WEST SUSSEX COUNTY COUNCIL CONSULTATION

TO:	Arun District Council FAO: Michael Eastham
FROM:	Stephen Gee WSCC - Highways Authority
DATE:	10 June 2020
LOCATION:	Land at Dappers Lane Angmering
SUBJECT:	DC/20/0881 84 No. dwellings, public open space, play areas, associated infrastructure & landscaping.
DATE OF SITE VISIT:	n/a
RECOMMENDATION:	Further Information
S106 CONTRIBUTION TOTAL:	-

Proposed Footway Tie-in

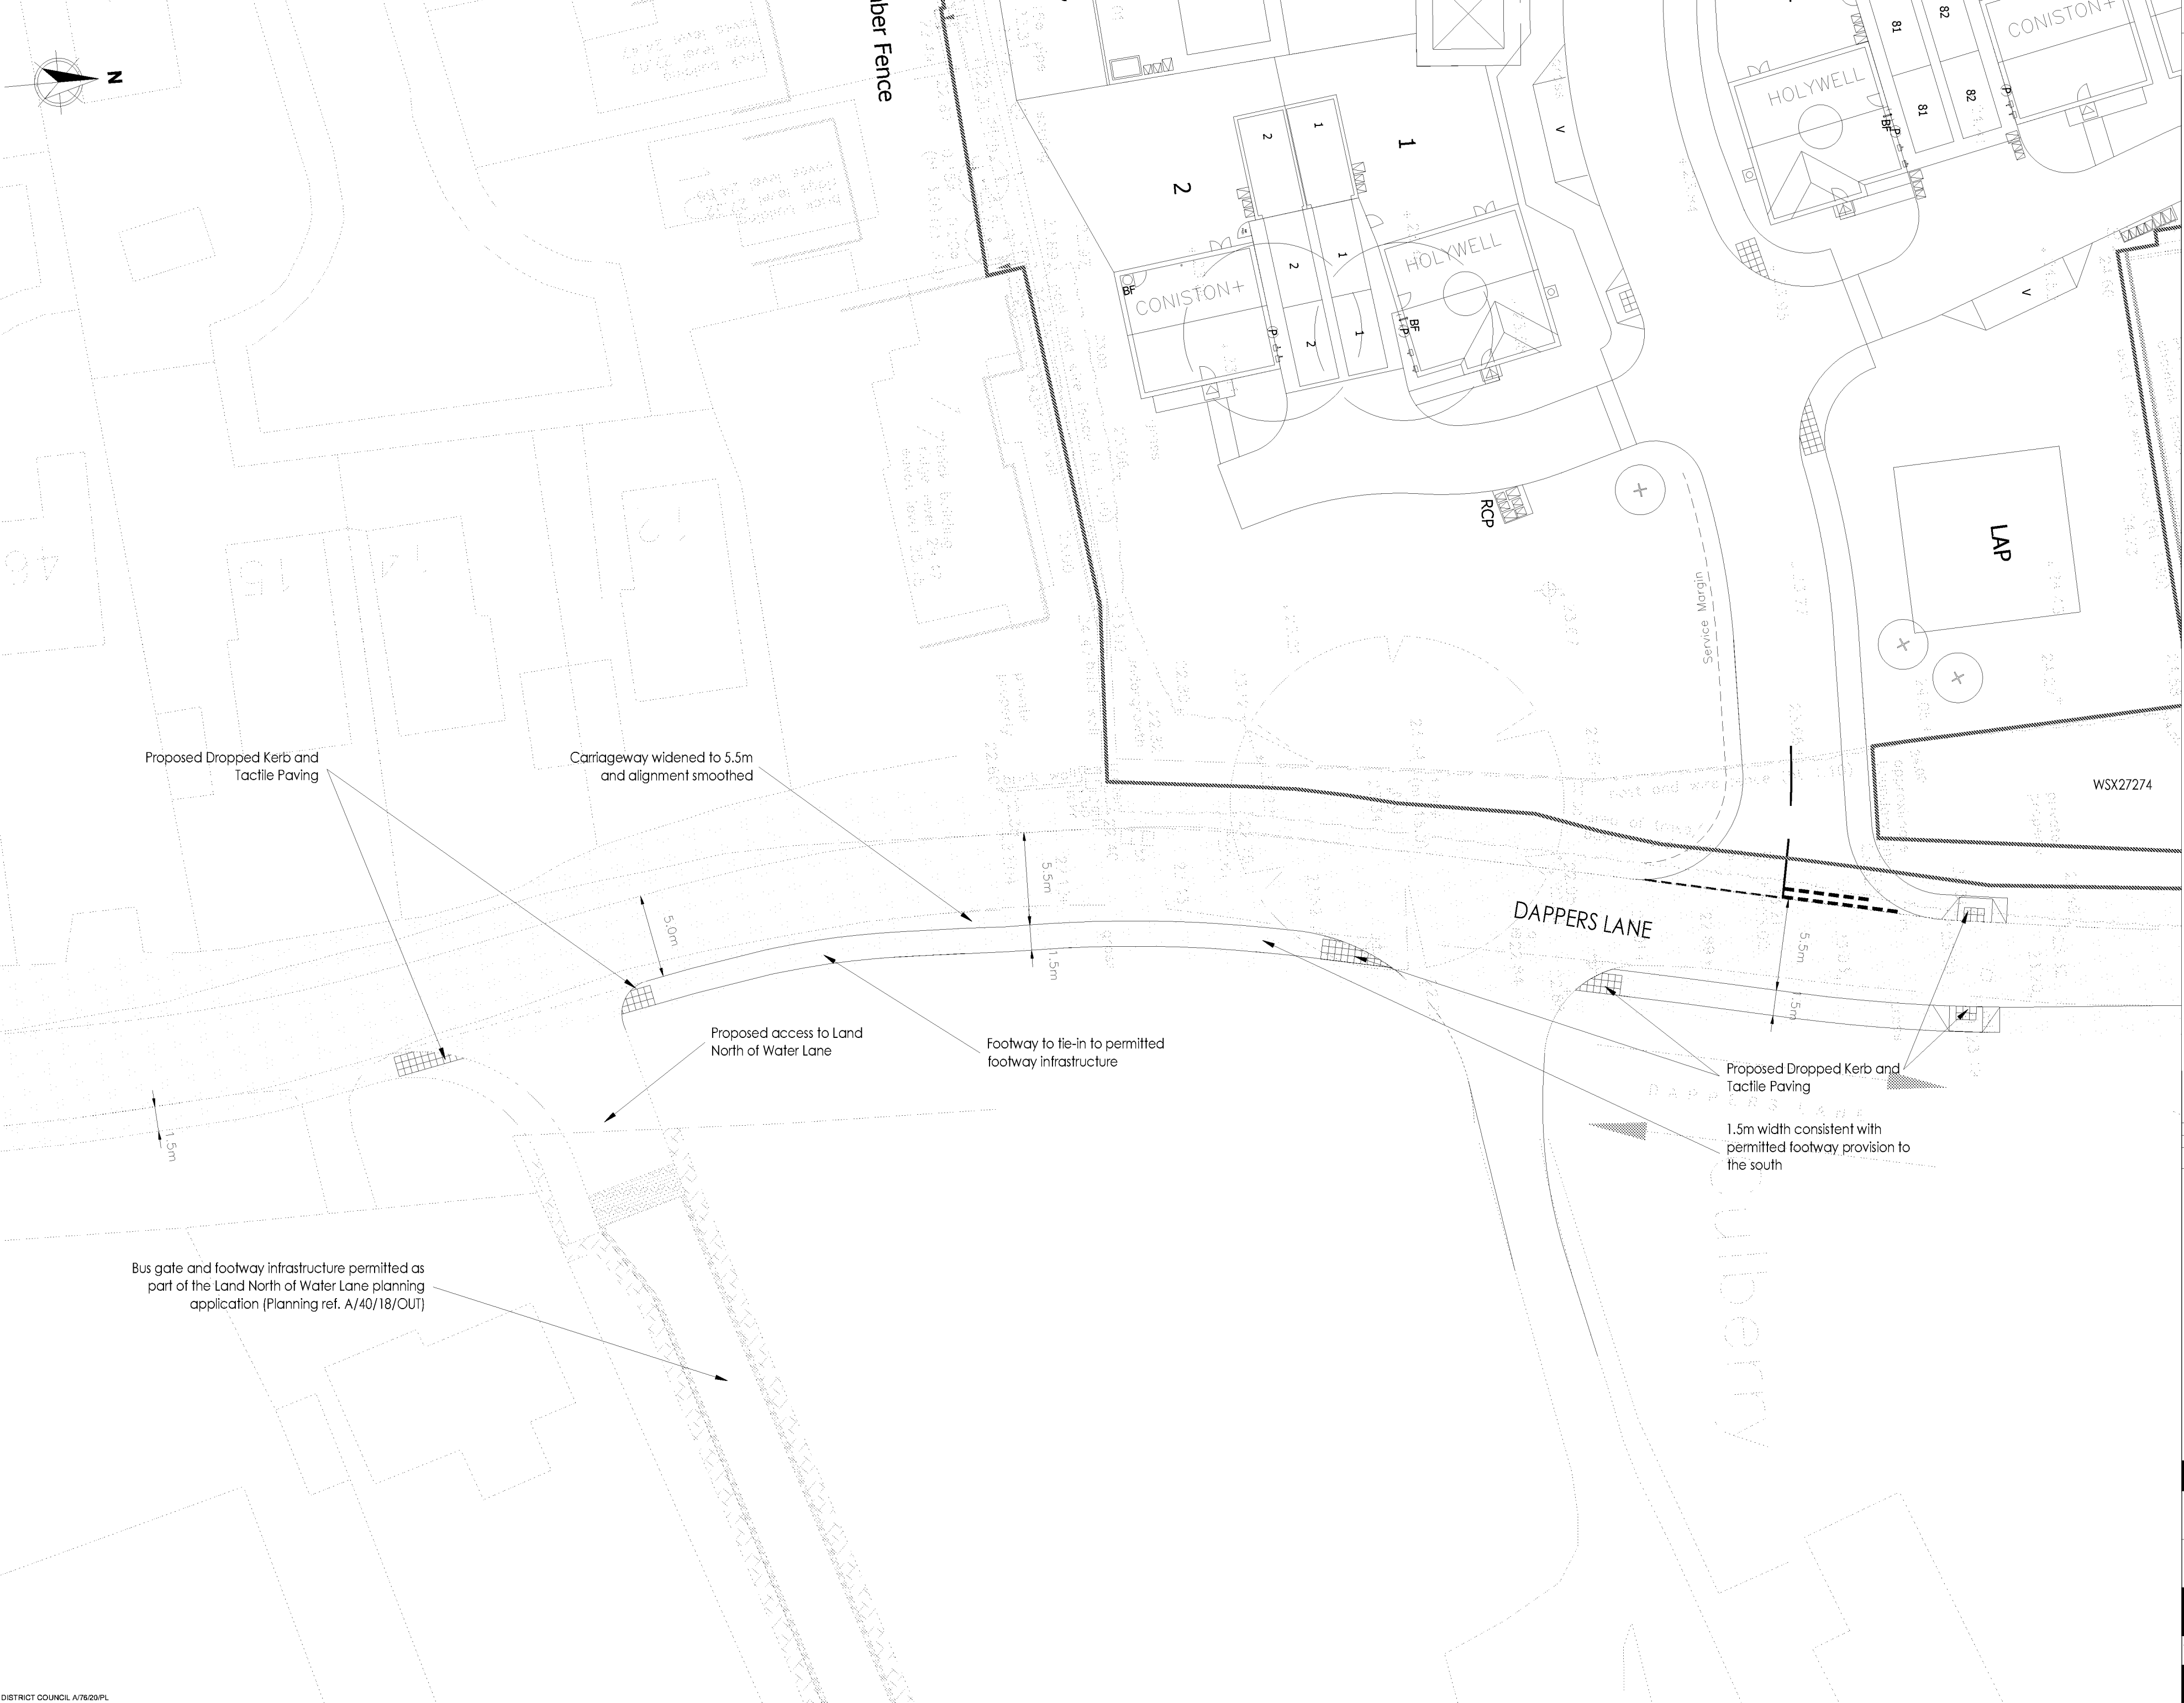
The TA notes that a 1.5m footway would be provided on Dappers Lane to connect into infrastructure on the easternside being provided by neighbouring developments.
